J ROBERTS DESIGN LTD
STRUCTURAL AND CIVIL ENGINEERING CONSULTANTS

Ref – JR/4097

5 Bradleys Lane, Hoveringham, Nottingham, NG14 JG - Structural Inspection

2 Existing Plan  
Scale: 1:50

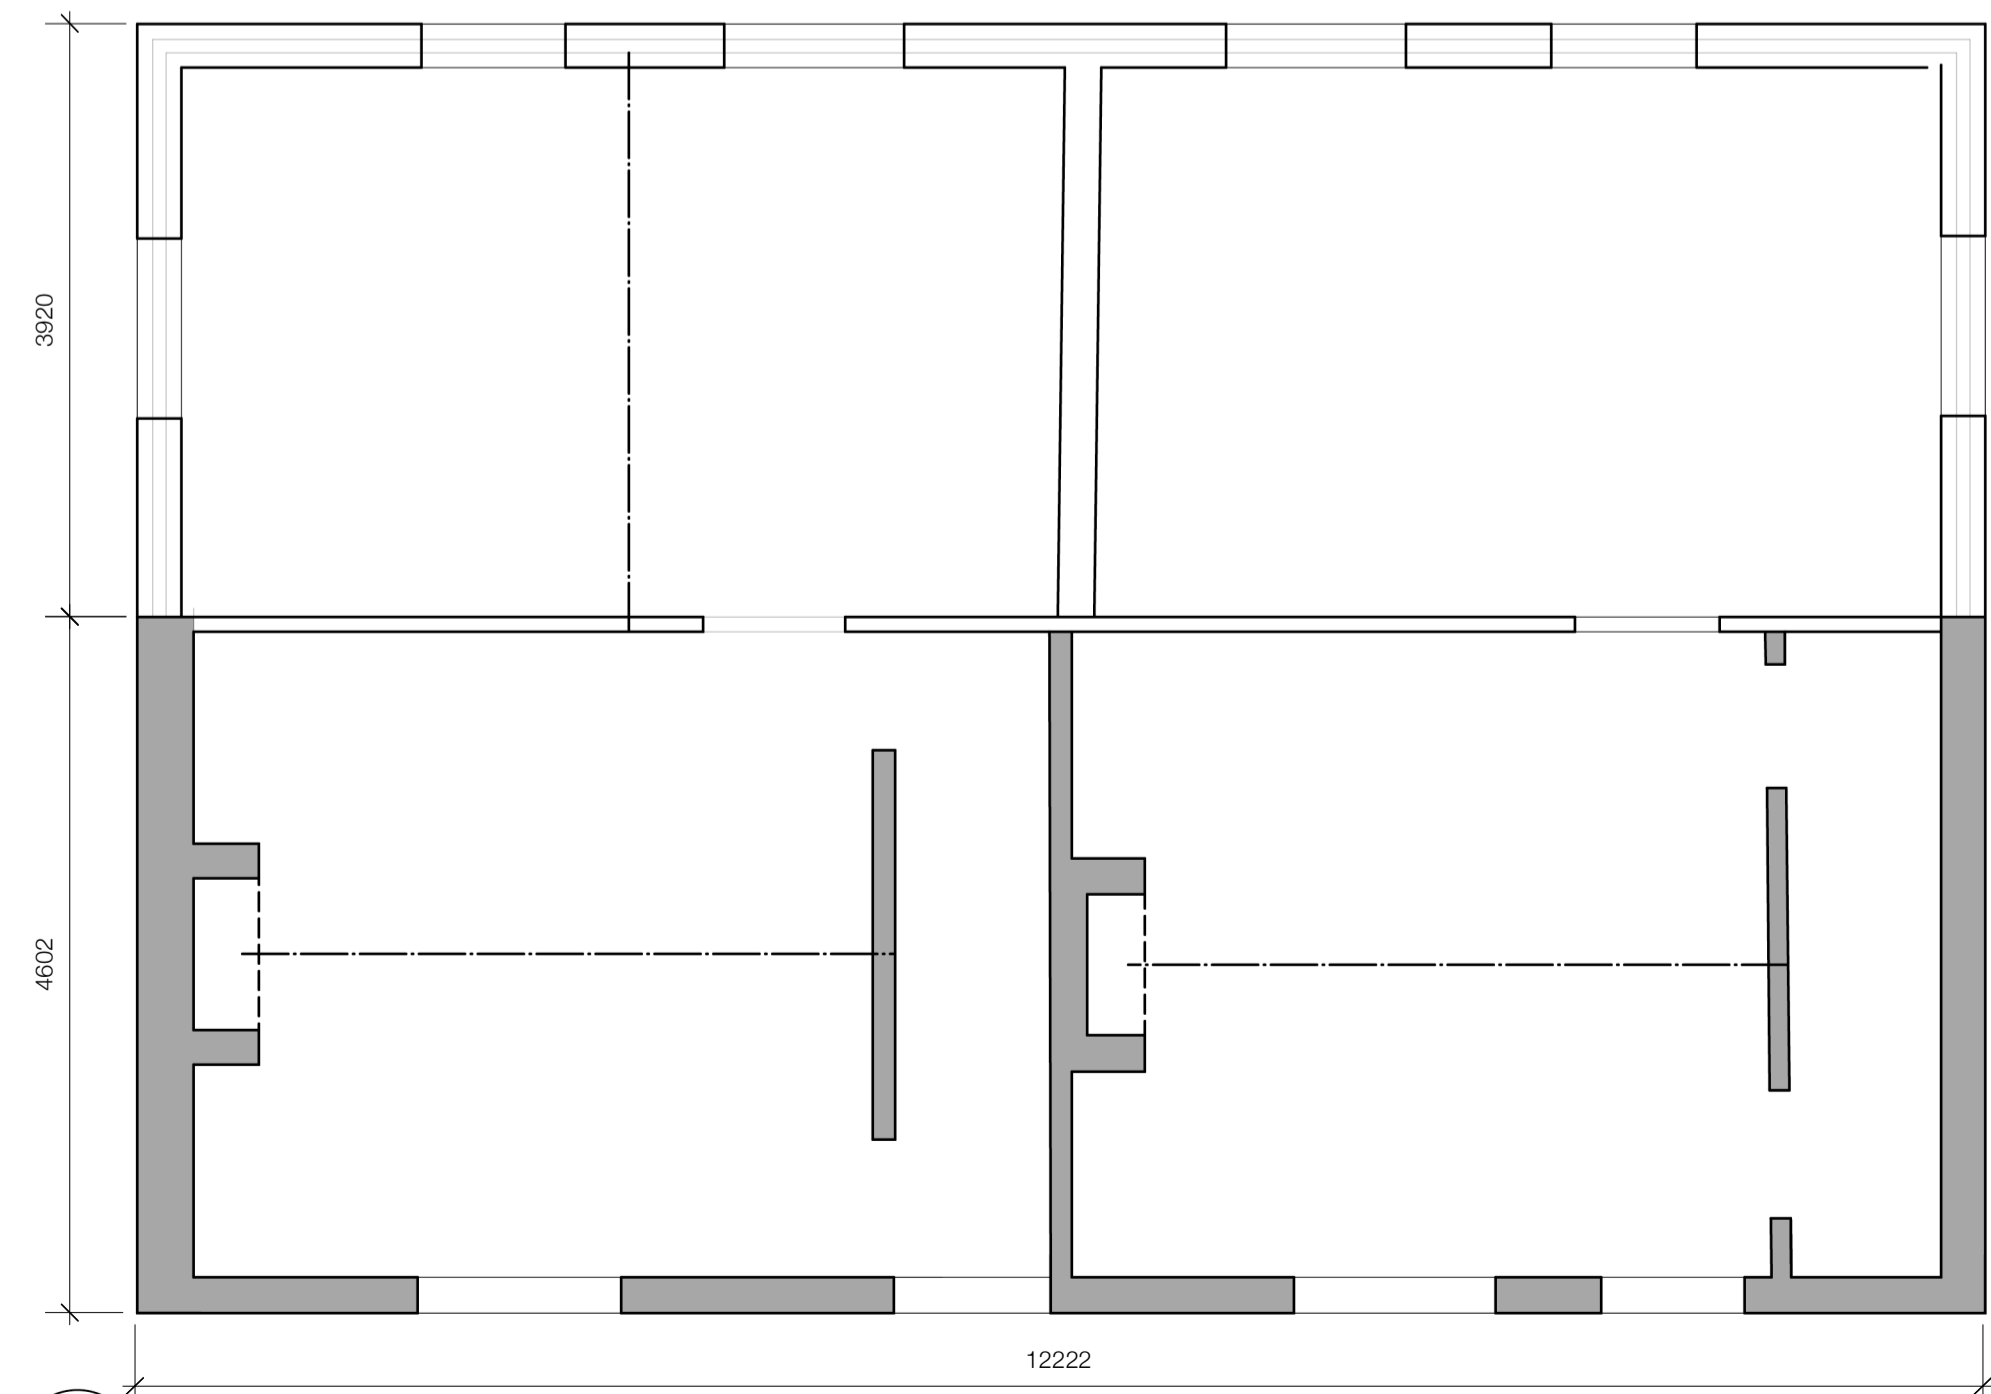
3. The plumb and level of the external and internal walls were checked at selected locations and generally no extreme dips or leans were detected.
4. Within the northern side for the property an existing internal pier appears to have settled historically by some 150mm indicated within the doorframe and wall dado rail. No vertical movement was noted on the front elevation indicating the pier is unlikely to be tied into the pier and potentially doesn't have a competent foundation.

5. On the original front elevation diagonal cracks and vertical slippage of the brick arches were observed above the ground floor window heads. The remainder of the property appears to have had new proprietary steel lintels installed as part of the extension works.

6. Continuing to the north east corner of the gable wall it appears that a section of wall had collapsed resulting in lateral movement of circa 200mm in the masonry and rotation of the masonry at the corner. Loose bricks are still present within the outerleaf of masonry. Internally cracking within the bedjoints are visible reflecting the movement observed. The corner is also noted to be an interface between the solid brick masonry and new cavity construction. The outerbrickwork has been toothed in around the corners, however the blockwork abuts the vertical face of the brickwork on the inner leaf. It is not known if masonry ties are present to the inner leaf of masonry.

The masonry fracturing and slippage of soldier coursing observed in the front wall is considered to be associated with an absence of lintel support to the outer face of brickwork, potential timber decay of the inner timber lintel and lack of a floor or roof structure providing lateral stability to the wall. We recommend the timber lintels are replaced with steel lintels, and the masonry above the window heads either repaired by crack stitching or the solid brick masonry is rebuilt locally.

The defects to the north gable will require the partial demolition of the defective areas of masonry and effective re-building of the corner up to the proposed gable wall level. The inner leaf of blockwork will need to be effectively tied into the solid brickwork at the corner with remedial ties where new or crack stitching around the internal corner of the wall where the blockwork is to remain in place.

The internal pier that has apparently dropped is proposed to be removed as part of the new dwelling configuration, hence no further remedial works for the pier are required.
